Wylfa Newydd Local Impact Report

Chapter 12: Lighting

December 2018

PINS Ref: EN010007

Figure 4-1 Construction zones within the Wylfa Newydd Development Area

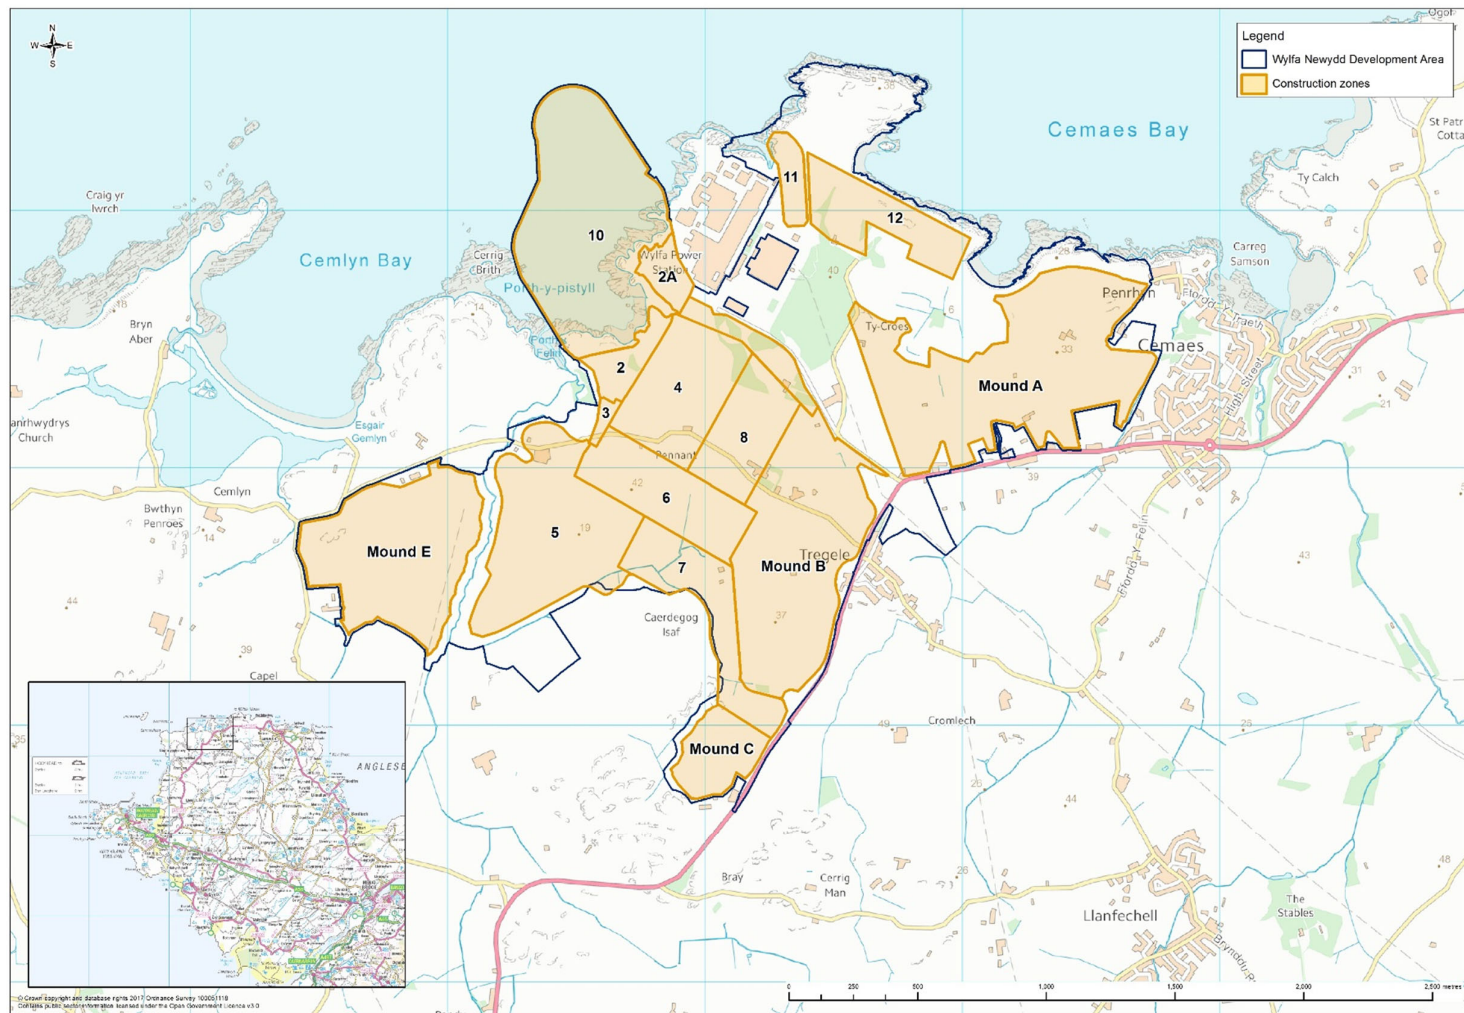
1.4.15 IACC do not consider that the implementation of control measures for construction lighting is sufficiently robust. Specifically, it is stated that the appropriate design of construction lighting would only be achieved 'where practicable'. It is accepted that there will be situations where it may be impracticable to implement certain control measures in certain situations, however, specifics of such potential outline situations are required, along with a definition of 'where practicable'. For instances of impracticability, the expected residual effects should be determined on an informed qualitative basis.
